# Meeting Notes

Re: U-2509AB Concurrence Point 4B Meeting Minutes

J.R. Hopson opened the technical portion of the meeting by providing an overview of the natural resources in the general vicinity of the project to the merger team. He then provided a summary of the hydraulic avoidance and minimization efforts as well as stormwater treatment practices for the project. Following the overview, the preliminary drainage design plans were reviewed, sheet by sheet, and the following outlines the discussions held on each sheet:

PROJECT REFERENCE NO. U-2509AB	SHEET NO. 04
RW SHEET NO.	
ROADWAY DESIGN ENGINEER	HYDRAULICS ENGINEER
INCOMPLETE PLANS DO NOT USE FOR R/W ACQUISITION	
DOCUMENT NOT CONSIDERED FINAL UNLESS ALL SIGNATURES COMPLETED

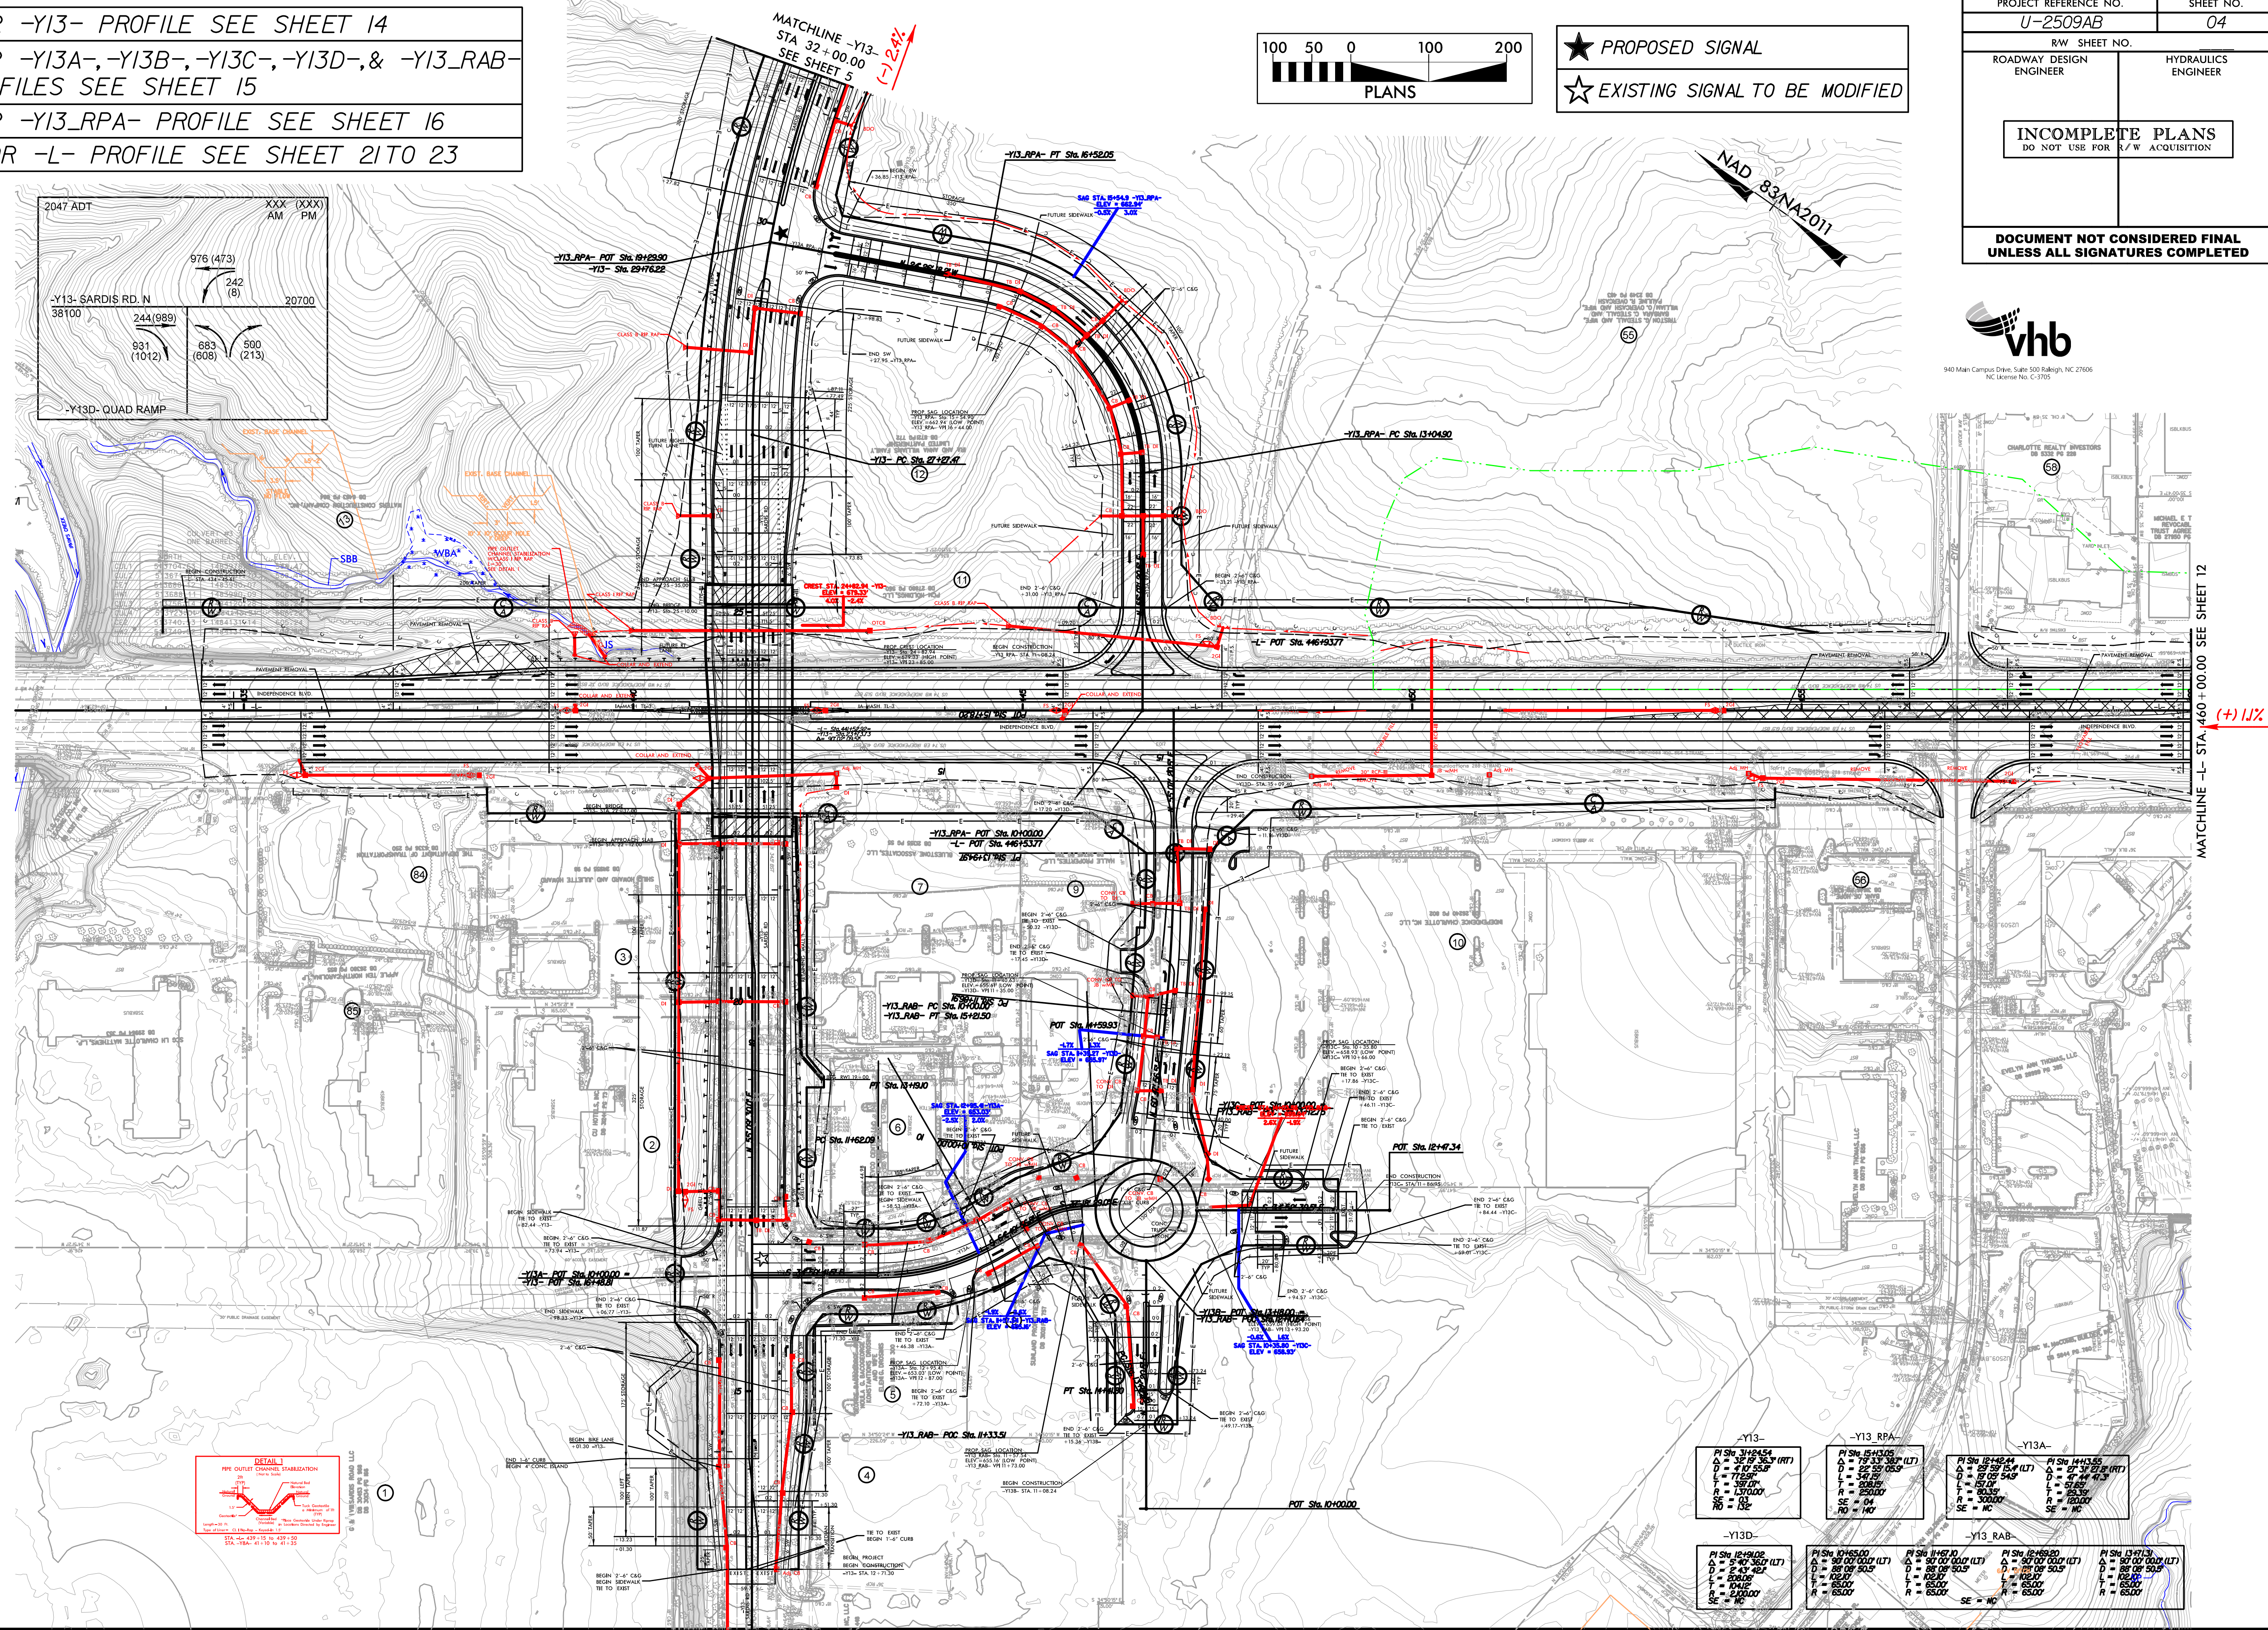
- J.R. Hopson identified areas where pavement was being replaced with vegetated conveyance. Susan Locklear asked if vegetated swale criteria was being met. J.R. Hopson replied that in most cases along the project, it was. Susan Locklear then asked that we incorporate a note stating the vegetated swale criteria was being met on the plans. After the 4B meeting, it was determined that the vegetated swale criteria and where it applies will be noted on the SMP, as is standard practice.
- Dave McHenry expressed concern over whether rip rap would be keyed in and if so, how far? He specifically was referencing the jurisdictional stream in the vicinity of -L- Sta. 440+00. Reid Robol showed the pipe outlet channel stabilization detail on this plan sheet to clarify the embedment of rip rap at 1.5'.

PROJECT REFERENCE NO. U-2509AB	SHEET NO. 05
RW SHEET NO.	
ROADWAY DESIGN ENGINEER	HYDRAULICS ENGINEER
INCOMPLETE PLANS DO NOT USE FOR R/W ACQUISITION	
DOCUMENT NOT CONSIDERED FINAL UNLESS ALL SIGNATURES COMPLETED

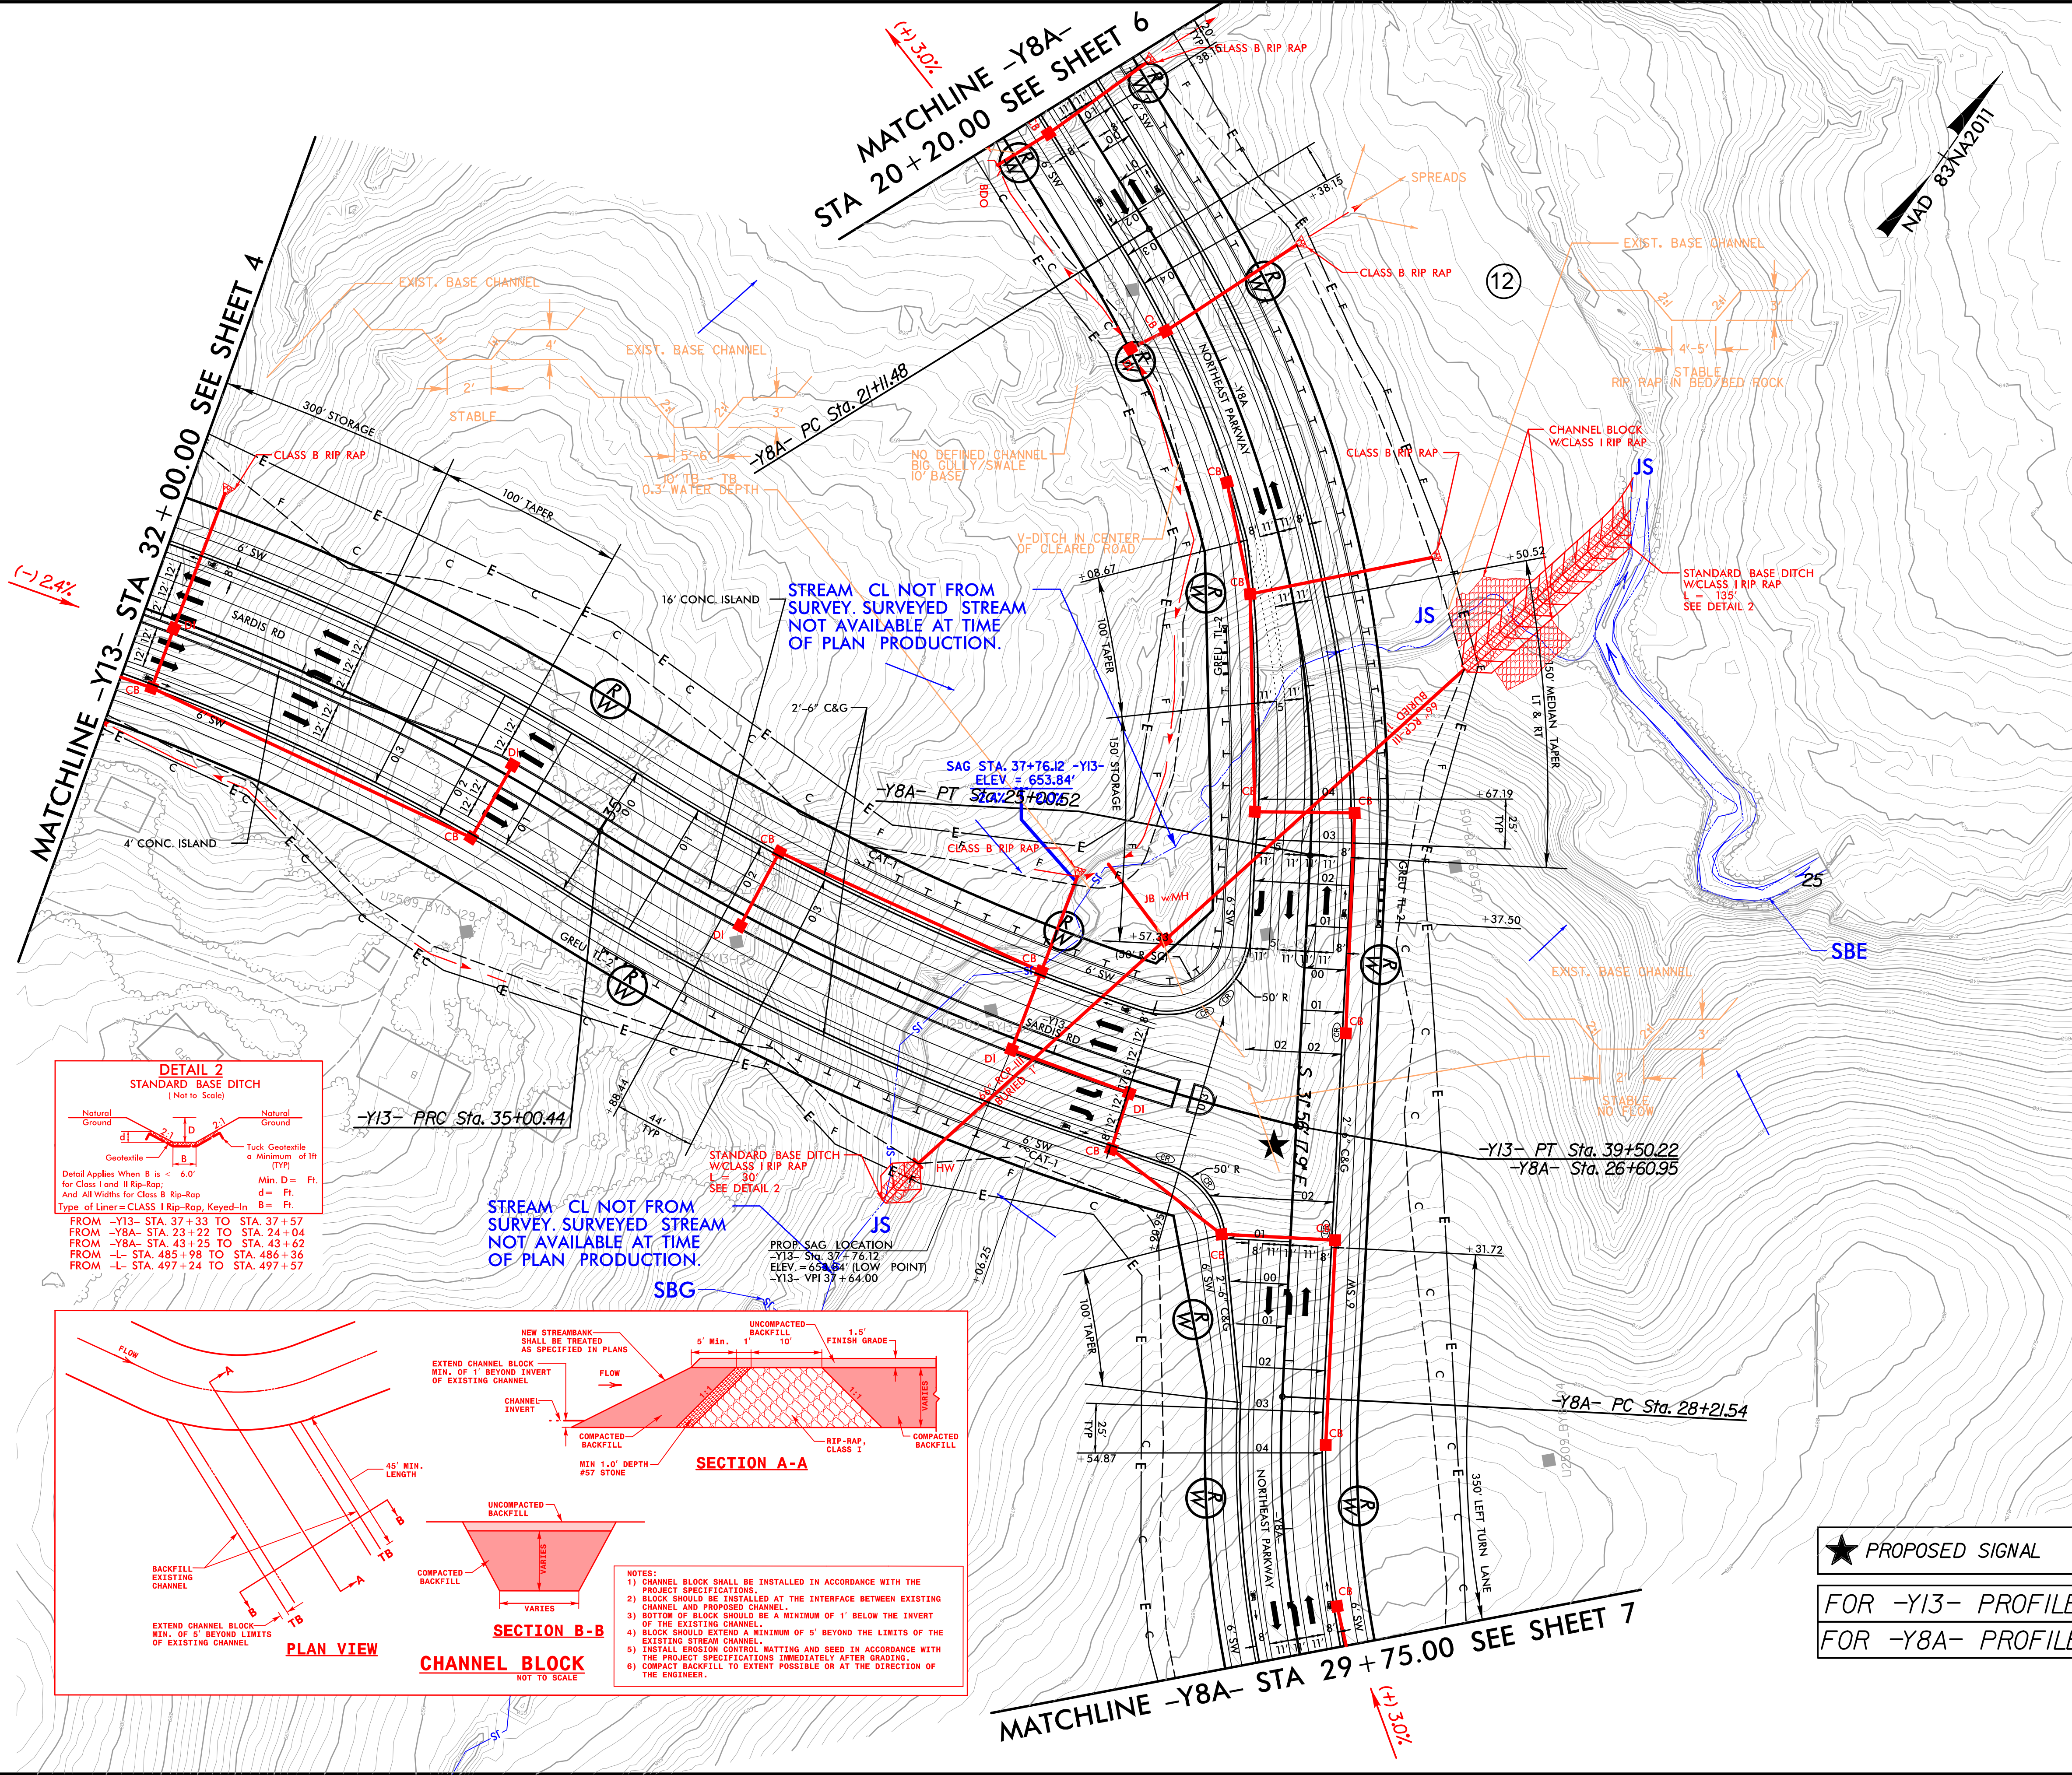
- J.R. Hopson detailed the 66" RCP going under both -Y13- and -Y8A- alignments as well as the design process taken to get there. Previously an alternative was explored that had a separate cross pipe under each alignment, but the base ditch required to convey flow between them would have had widespread right of way impacts. Steve Brumagin noted that he appreciated the additional commentary about how the alternative was reached.
- Brian Key noted that design was ongoing in the plan view NW quadrant and that the developer would likely have some responsibility in building the road.
- Brian Key also noted that Sardis Road would be stubbed out beyond its current limits at the intersection of Northeast Parkway.
